Letter of Intent

13645 Gymkhana Road, Peyton, CO 80831
Parcel No: 4329001016
Parcel Size: 8.33 Acres
Zoning A-5

This project includes a request for a Special Use Permit to allow an extended family member to reside in a modular home to be placed on the west side of the existing primary residence.

CUSTOMER: HARPER, BARRY  
ADDRESS: 13645 GYM KHANA RD,  
LEGAL: LOT 10, CORRAL RANCHES, SUBDIVISION  
TAX ID: 4329001016  
ACRES: 8.33  
SCHOOL DIST: 49, FALCON

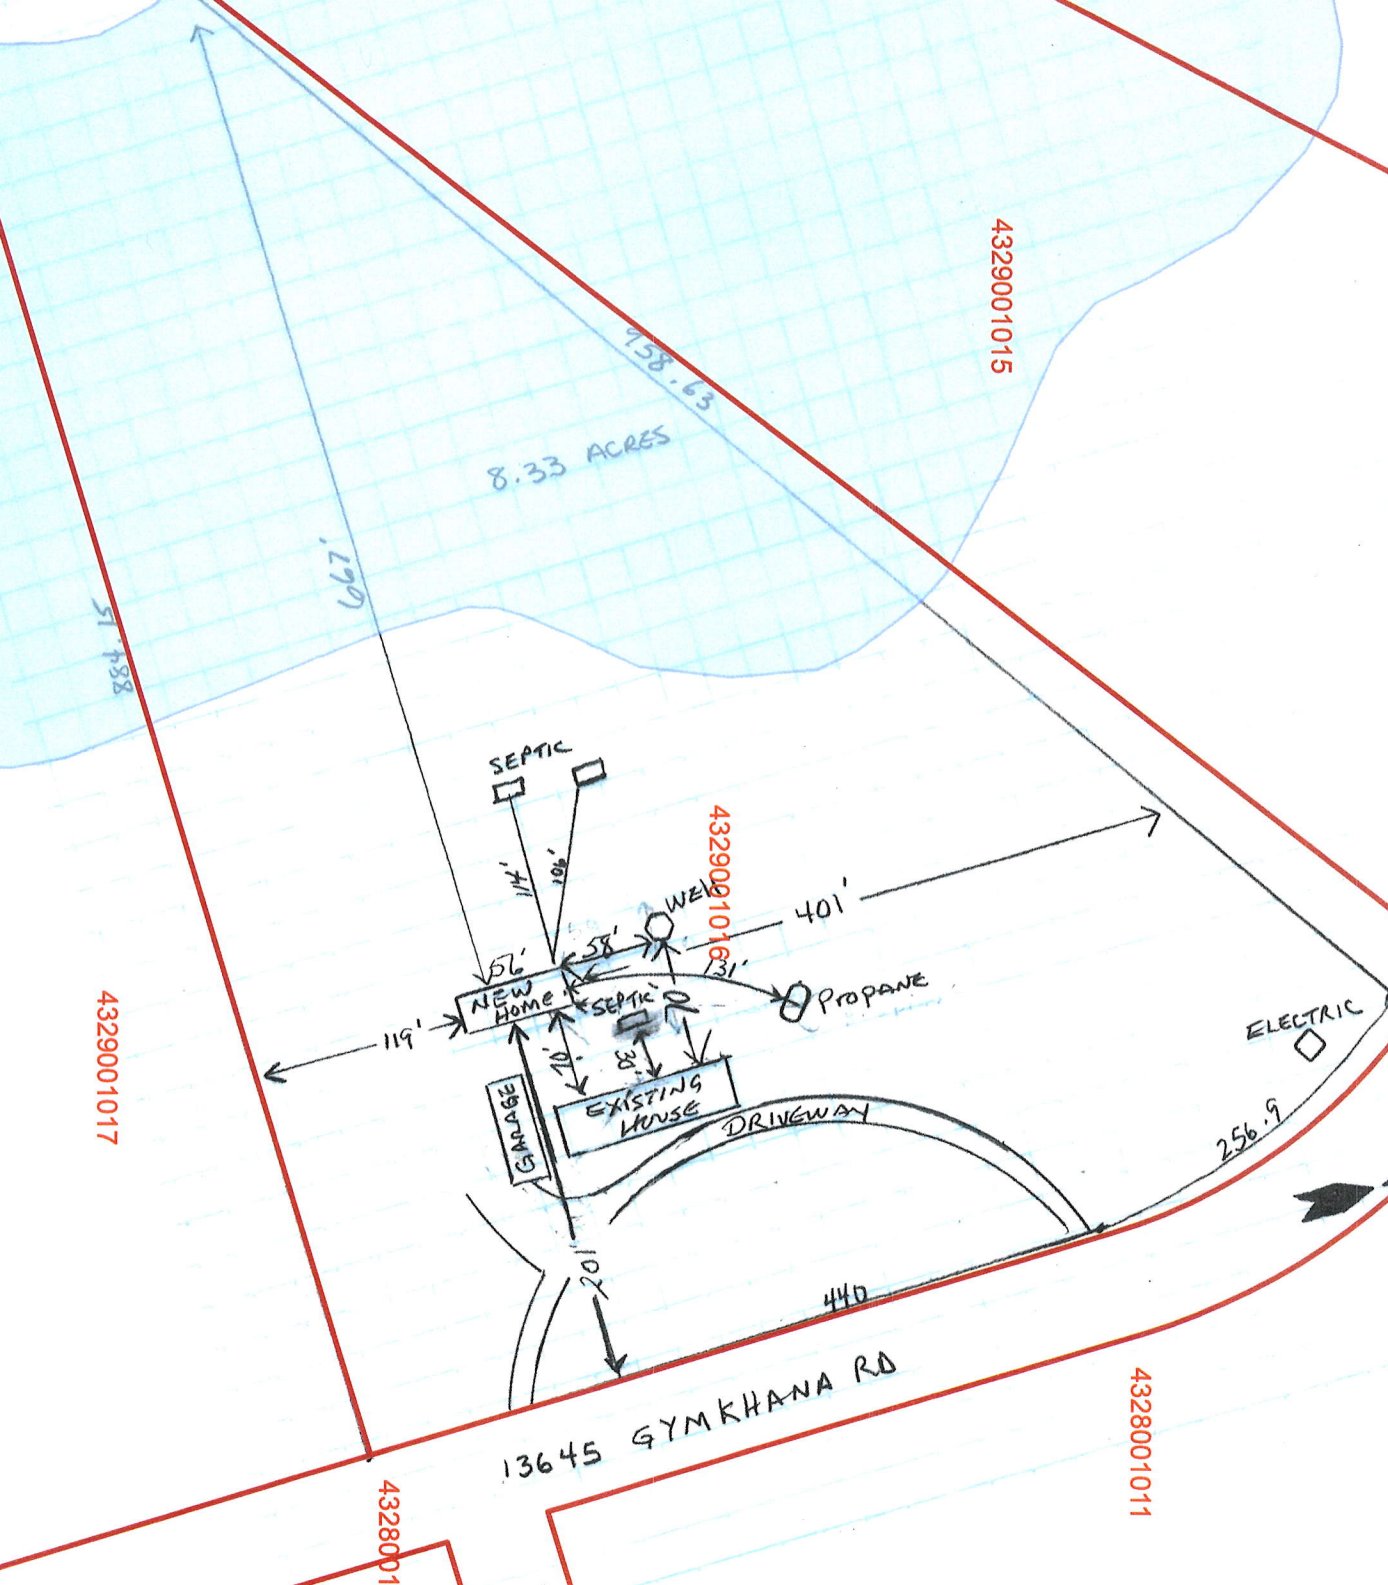
Above, you refer to the modular structure as a "new home." LDC specifically refers to this type of use as an "accessory living quarters," and it is not considered a second dwelling unit.
